Structural Special Inspections Report

**Portland Fire Department
Munjoy Hill Fire Station Monopole Replacement**

City of Portland Maine
July 24, 2012

Structural Engineer of Record
Becker Structural Engineers, Inc.
75 York Street
Portland, ME 04101
207. 879. 1838

SECTION 5  
3/4"=1'-0"

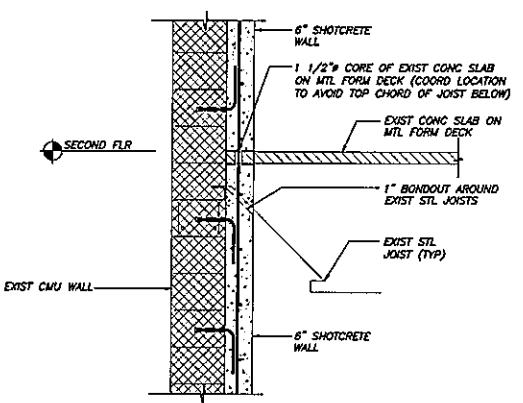
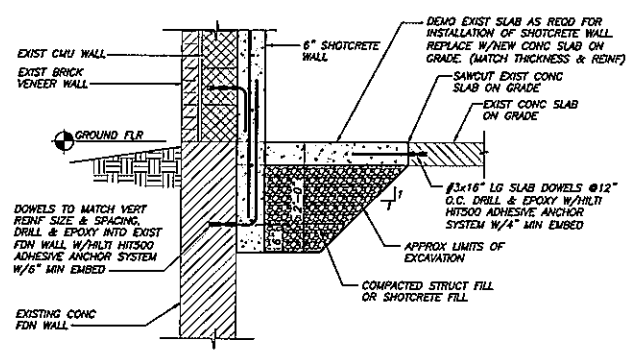
1. Some of the bent bars for Shotcrete Wall No. 2 that wrap around the existing joist in section 5 on S3 were being constructed with #7 and the contractor was having issues placing them. We confirmed that those bars can be #5.
2. The Top cord of the existing joists for Shotcrete Wall No. 3 were not bonded out as shown on Section 6 on S3. The contractor was notified confirmed that the bond outs will be added.

1. The contractor was placing shotcrete for Wall No. 2 while we're on site. We noticed the top cord of the existing joists for Shotcrete Wall No. 3 were not bonded out. We notified the contractor and the bondouts were added.
